Project: **134-140 MARSDEN STREET,  
PARRAMATTA (V BY CROWN)**

Report: **BCA ASSESSMENT REPORT**

Document: **103823-BCA-r2**

Date: 10<sup>th</sup> September 2012

Drawing Title
GROUND FLOOR

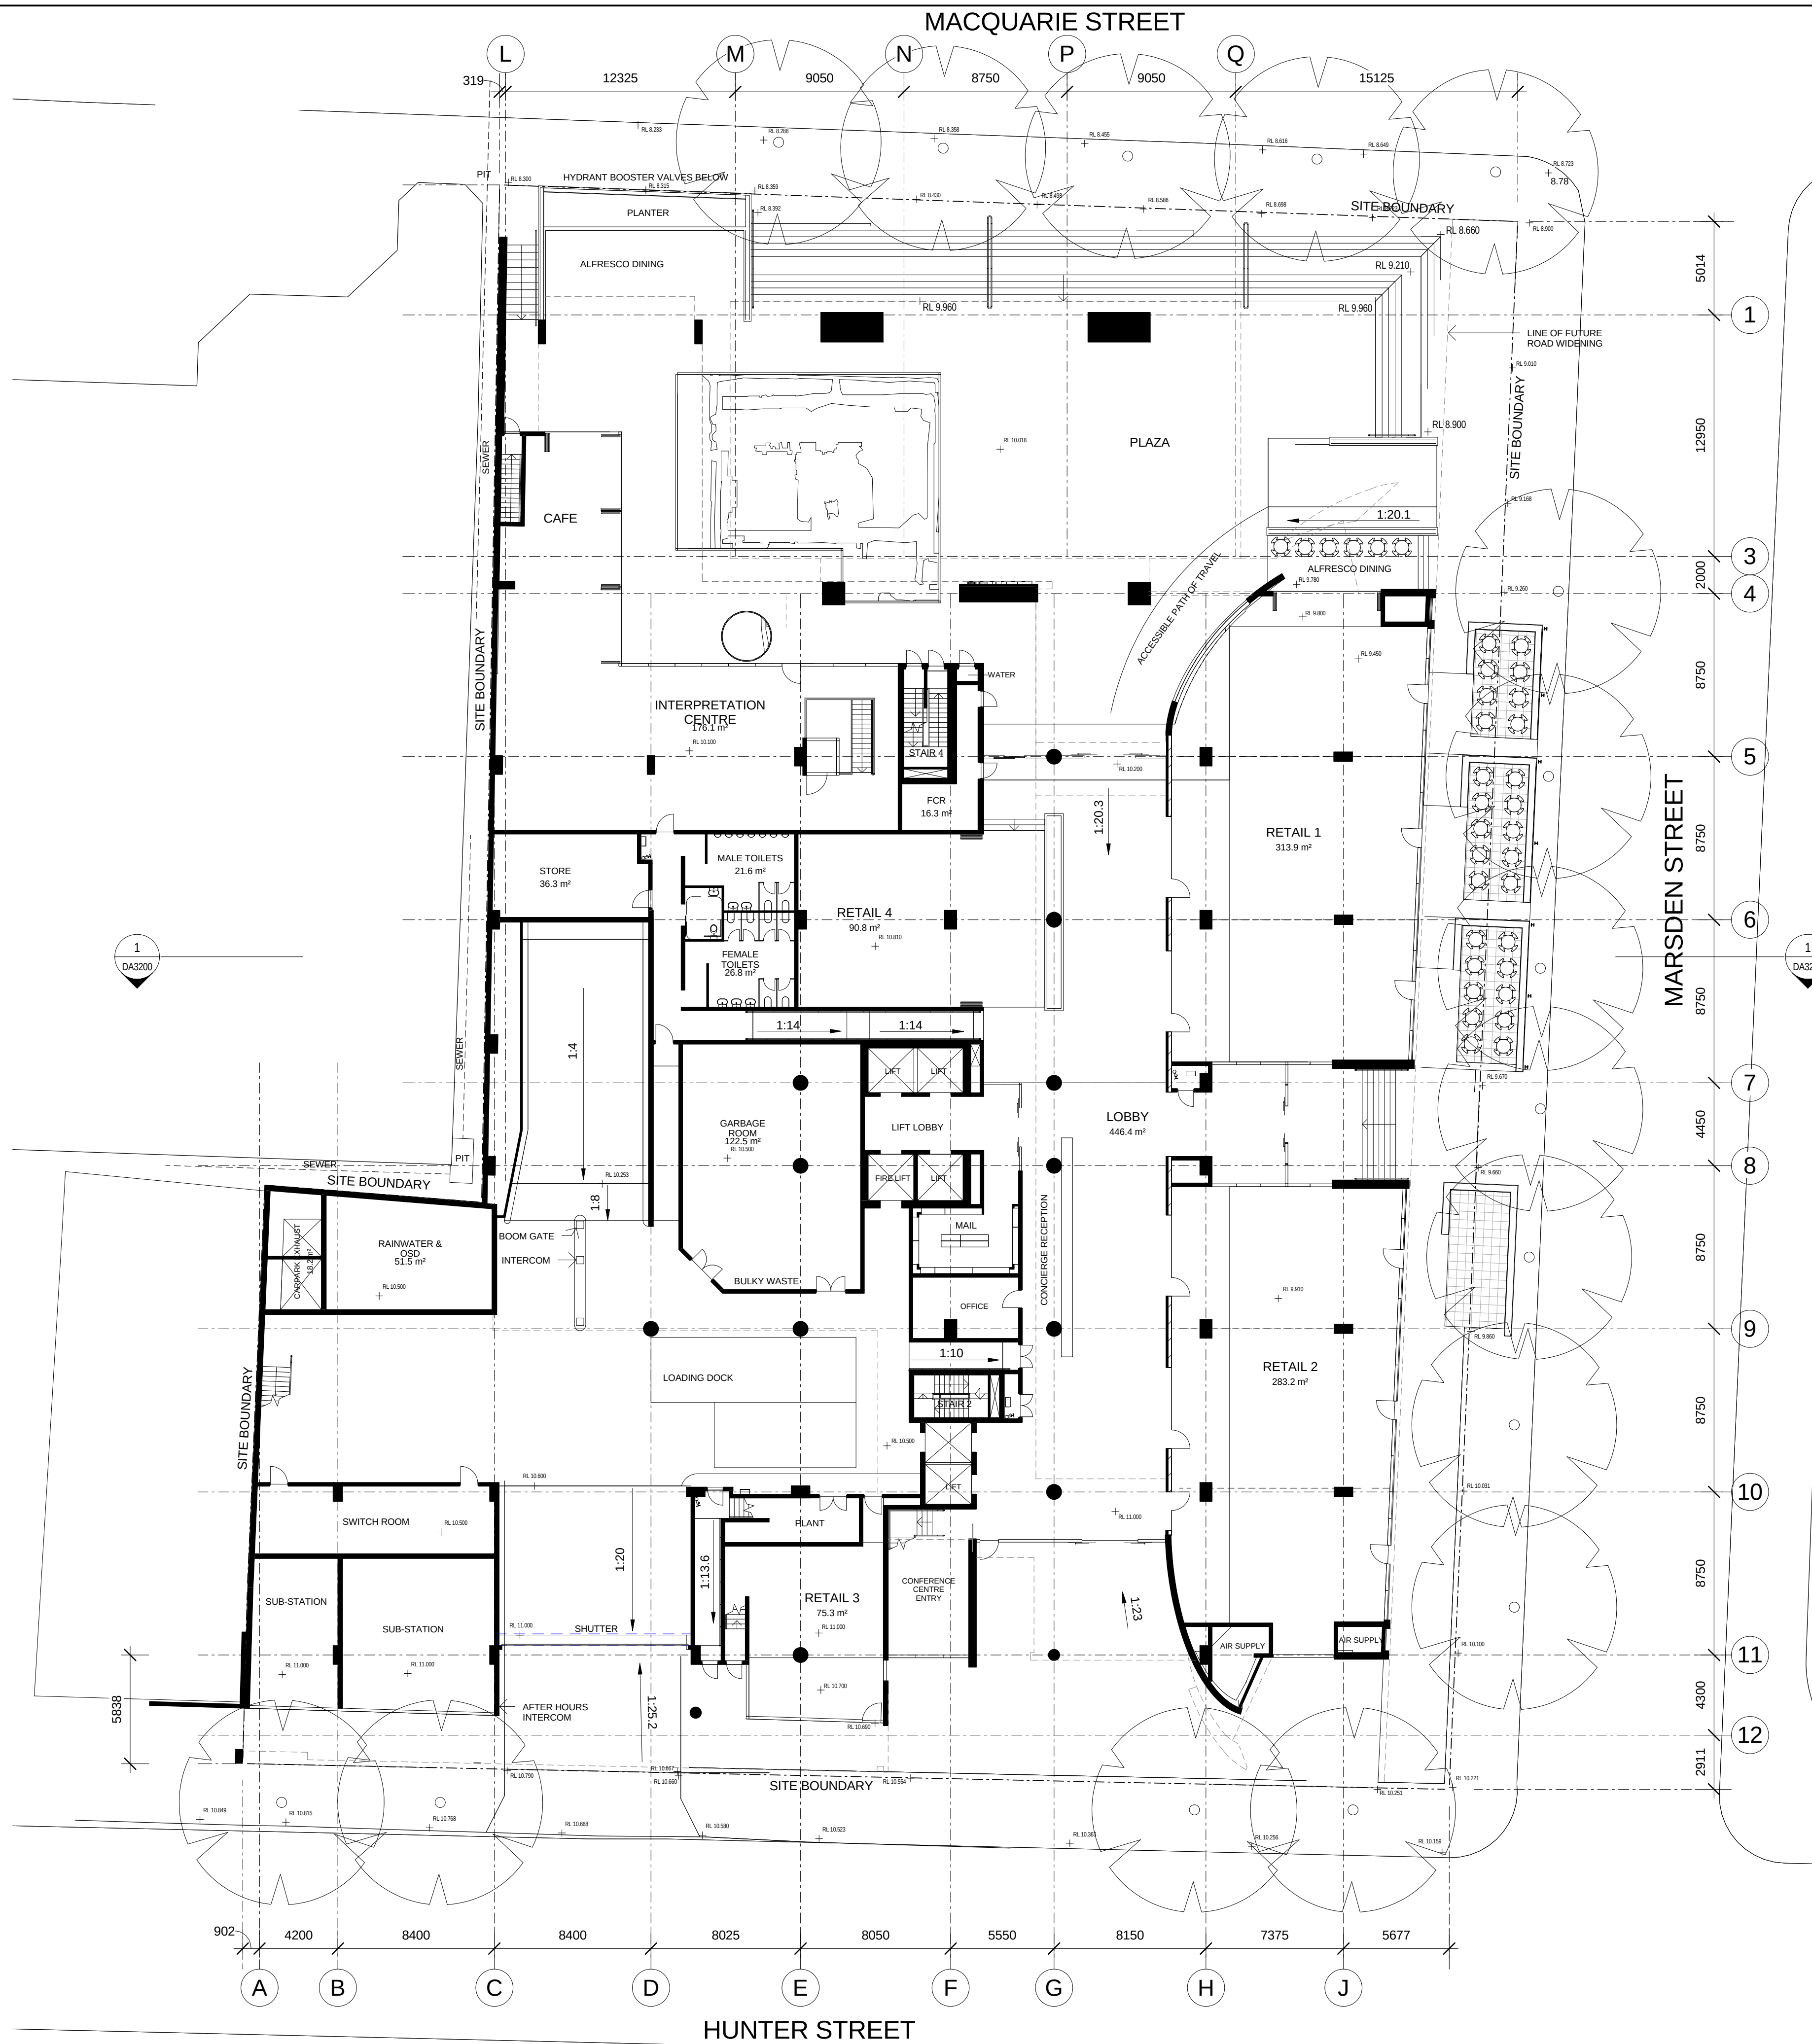
- a) There are 5 pedestrian entrances into retail tenancy 1, therefore 3 of the entrances are to be accessible in accordance with AS1428.1-2009. The plans indicate there is a 600mm difference in floor level between the lobby and the retail tenancy. The accessible entrances are to be distributed between Marsden St and the lobby area, and the accessible entrances are not to in excess of 50m from a non-accessible entrance.

- b) There are 6 pedestrian entrances to retail tenancy 2, therefore 3 of the entrances are to be accessible in accordance with AS1428.1-2009. The plans indicate there is a 1050mm difference in floor level between the lobby and the retail tenancy. The accessible entrances are to be distributed between Marsden St and the lobby area and the accessible entrances are not to in excess of 50m from a non-accessible entrance;
